Comments from Private Sector Housing:

Application No: LU/107/20/PL
Registered: 7th May 2020
Site Address: 15 Beach Road Littlehampton BN17 5HZ
Grid Reference: 502958 102047
Description of Works: Change of use from office on first & second floors (A2 Financial & Professional Services) to 2 No. flats (C3 Dwelling houses).

SCALE / 1:100 @ A3
DATE / 22.03.2017
DWG. NO / 080616 / TP.02 'A'

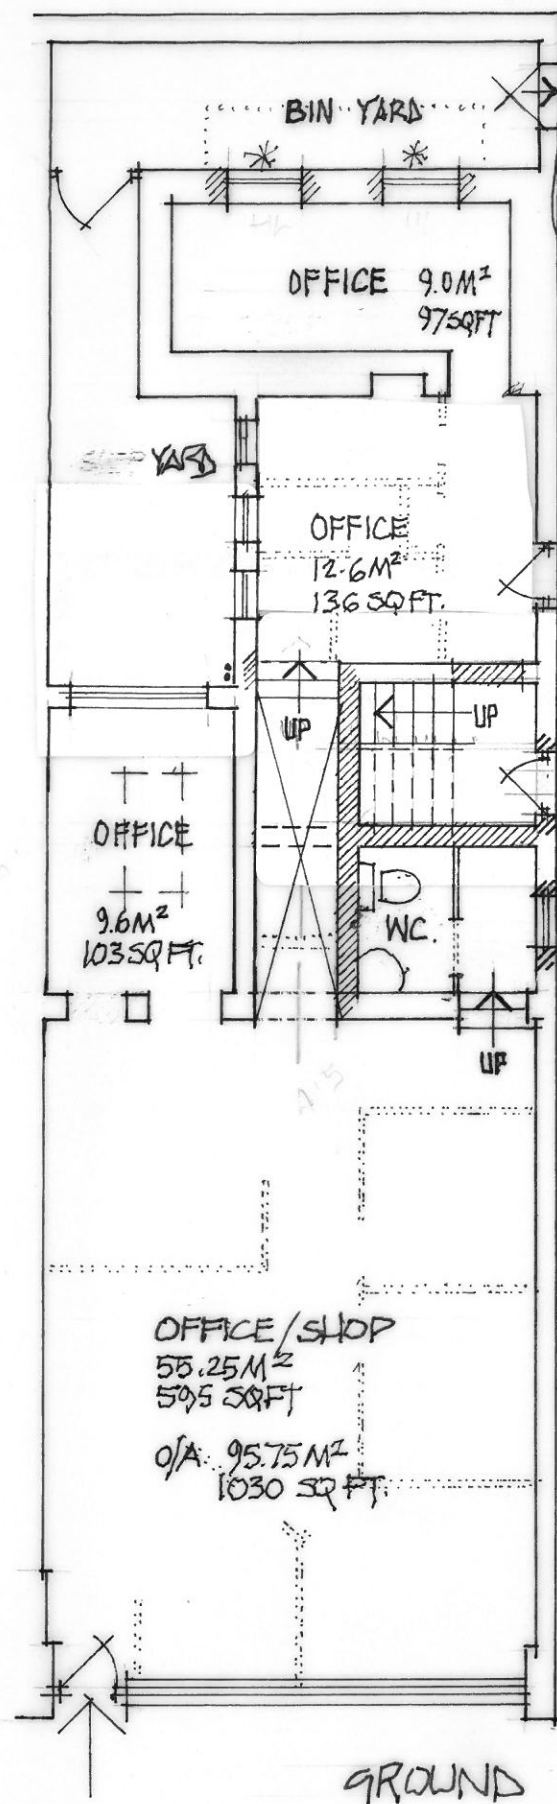
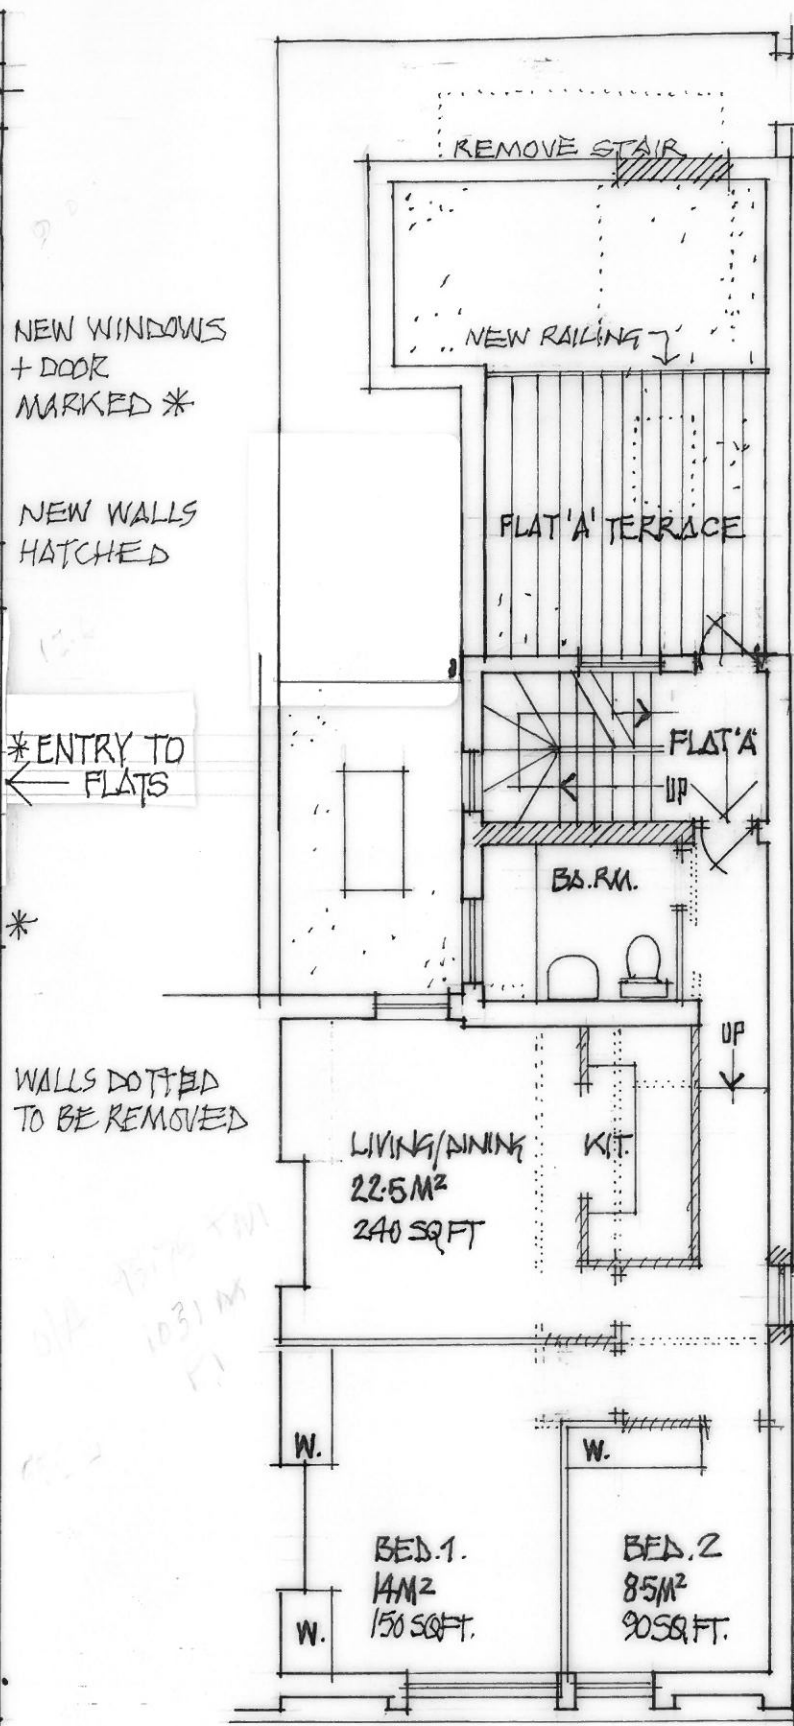
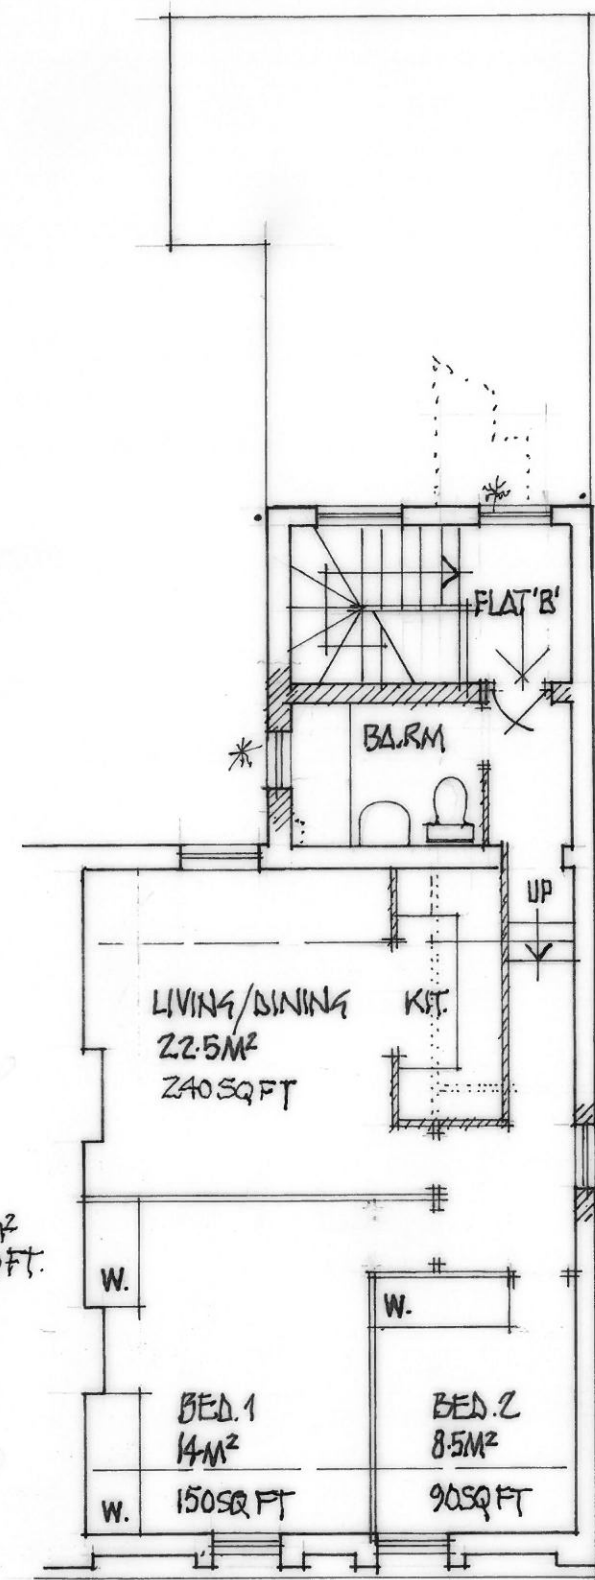
- There should be adequate fire separation between the commercial unit on the ground floor and the residential flats above.
- 30min fire resisting escape route, which would include providing a 30 minute fire resisting and self-closing fire door conforming to FD30S standard (includes intumescent strips, cold smoke seals, 3 fire-rated hinges and an overhead self-closing device) to each flat entrance door.

- Each kitchen/dining area and bedroom in each flat must be fitted with a close-fitting conventional door in order to protect the means of escape and provide for privacy in bedrooms.

- The window located in the stairwell on the first floor level which looks out on to the roof terrace of Flat A must be fire-resisting and non-openable in order to protect the means of escape from each flat, as this is the single means of escape for both flats.

- It is recommended that window opening restrictors, which have an override facility, are fitted to the lounge and bathroom windows of Flat A on the first floor, in view of the flat roof outside of it to deter unwanted attempts of using the windows as exit points by children. The opening should be restricted to 100mm.
- The windows in Flat B, on the second floor, should be fitted with window opening restrictors, restricting the opening to not more than 100mm.

- The railings proposed for the perimeter of Flat A Roof Terrace on first floor level must be a minimum of 1100mm in height, with any gaps in the railings not allowing a 100mm sphere to pass through it.

DWG.NE/080616/TPO3A'

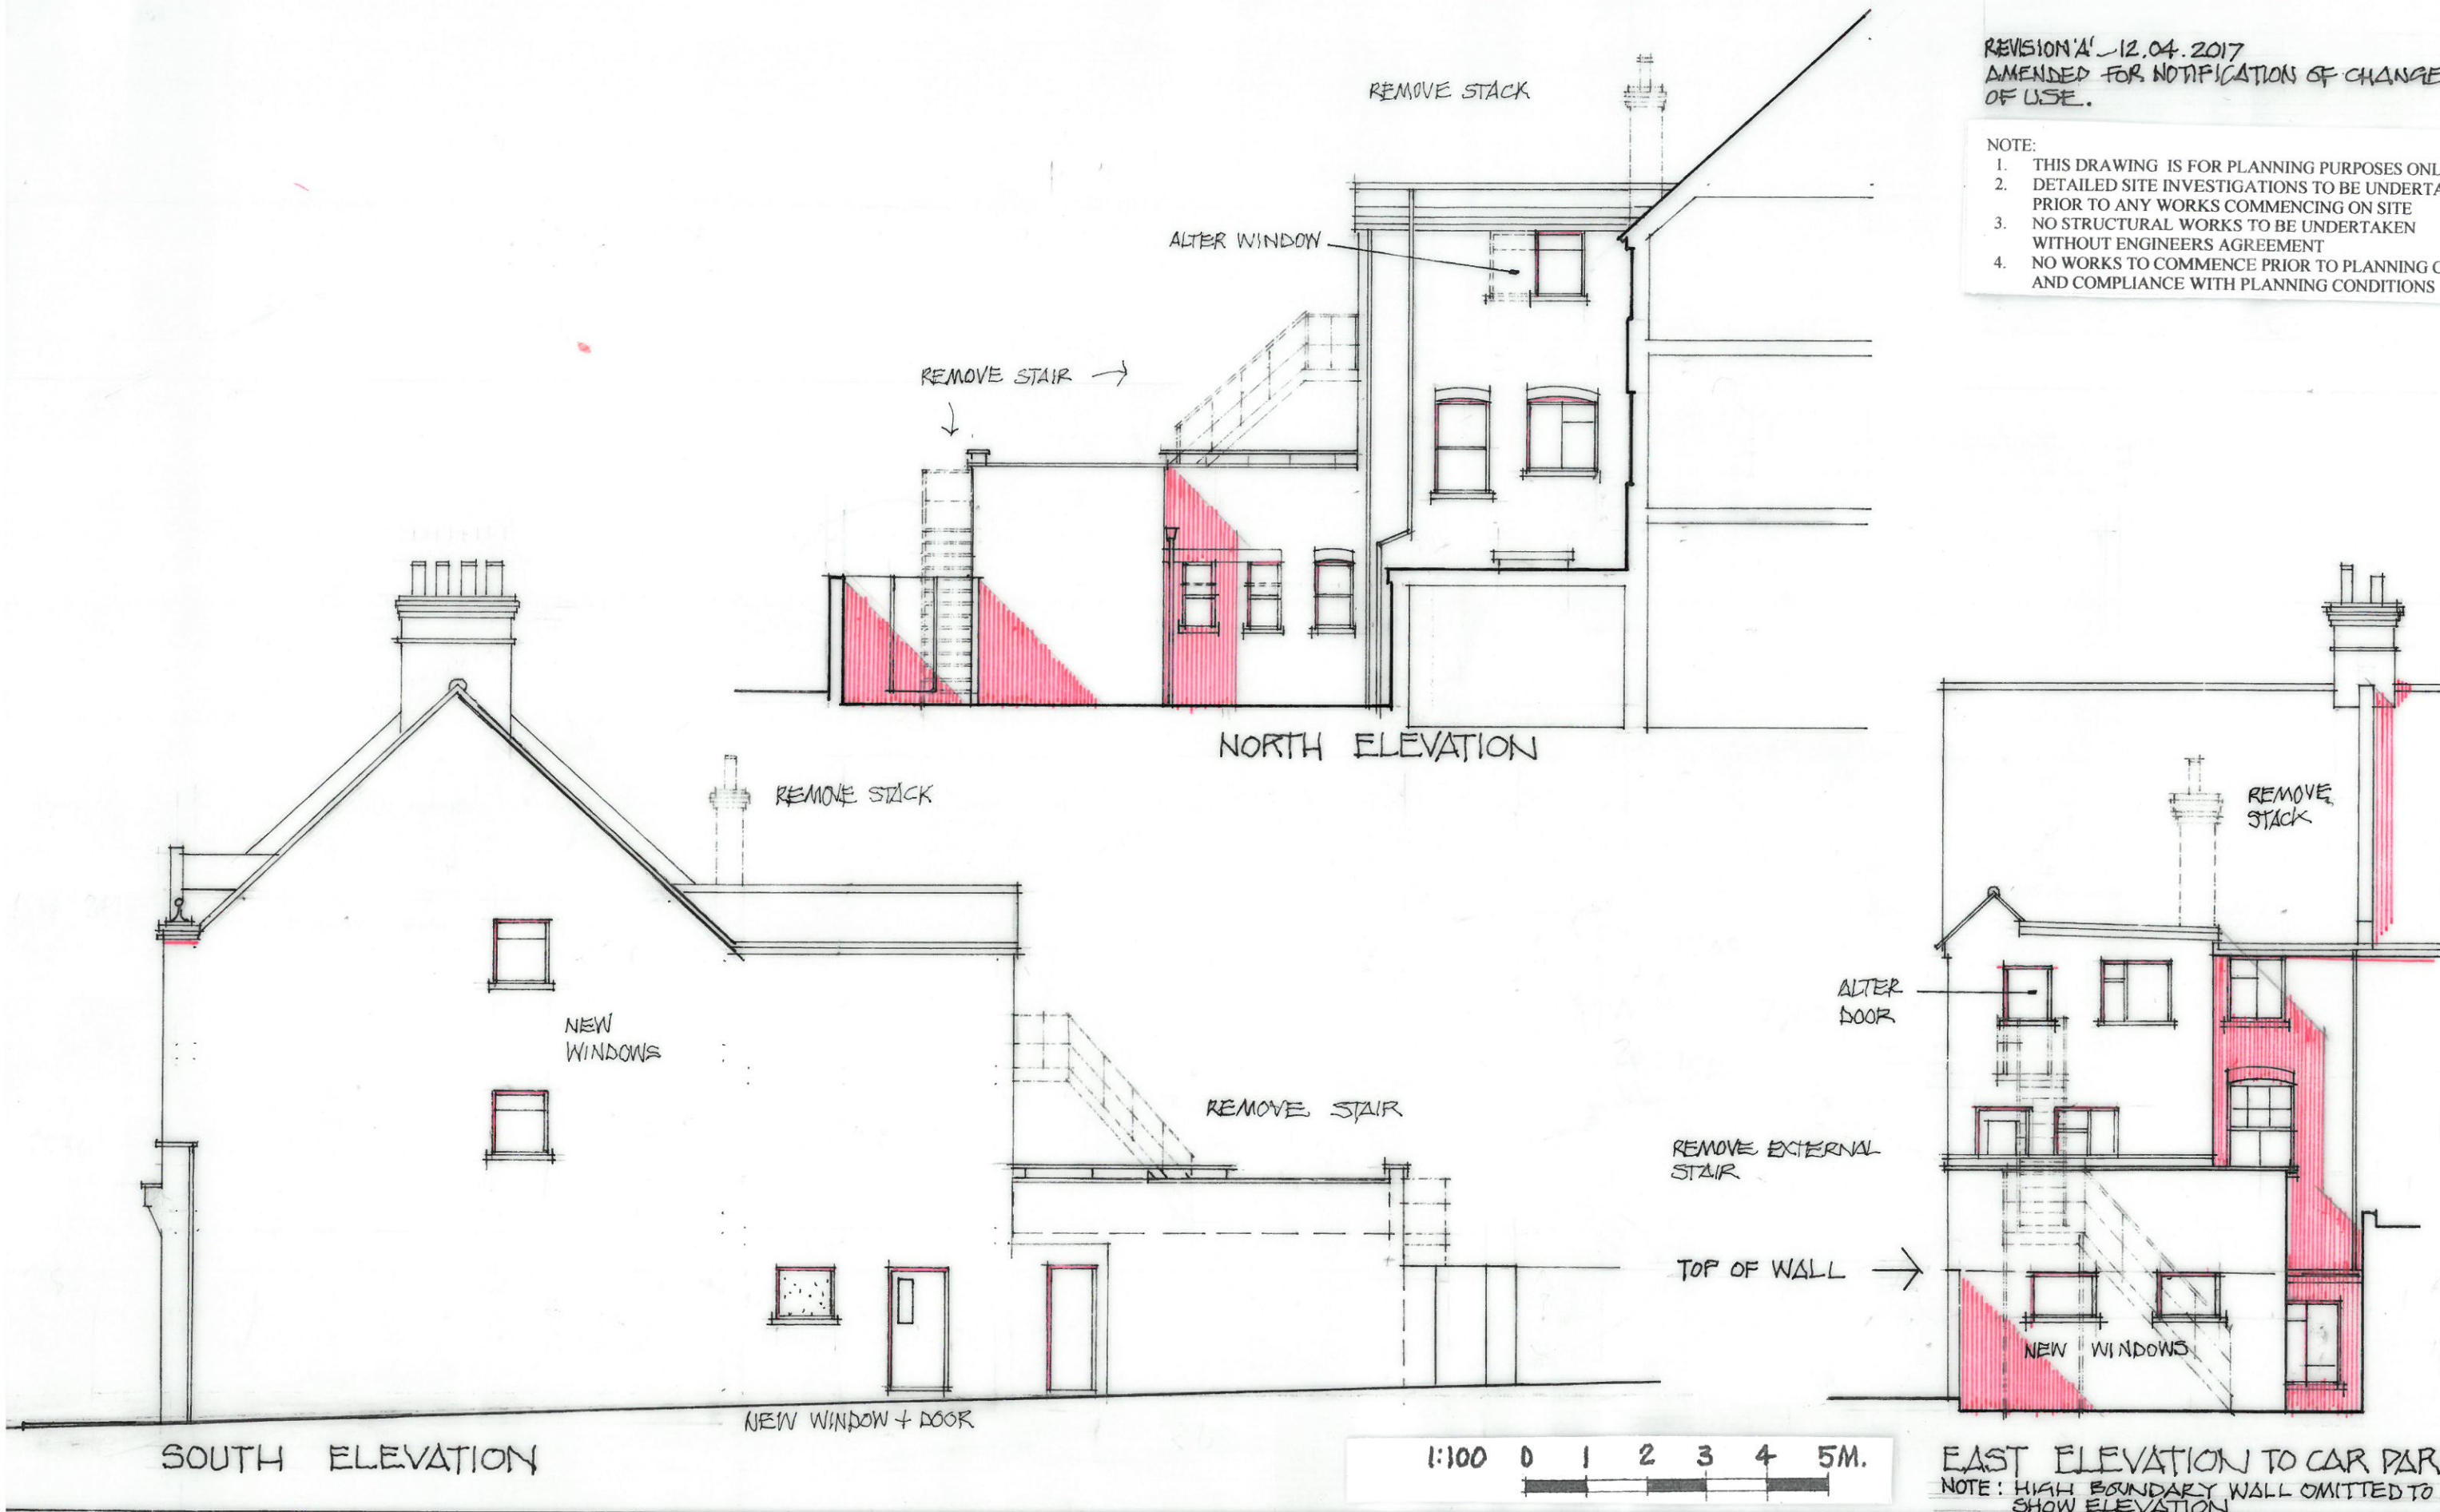
- The entrance door to the internal communal staircase, located at ground floor level, is in side wall of the building and in an entrance road to Manor Car Park. The road itself is narrow and it is felt that a protected area should be provided for persons entering and exiting the property via this doorway. We recommend seeking further advice and guidance from Arun District Council Planning department in this regard.
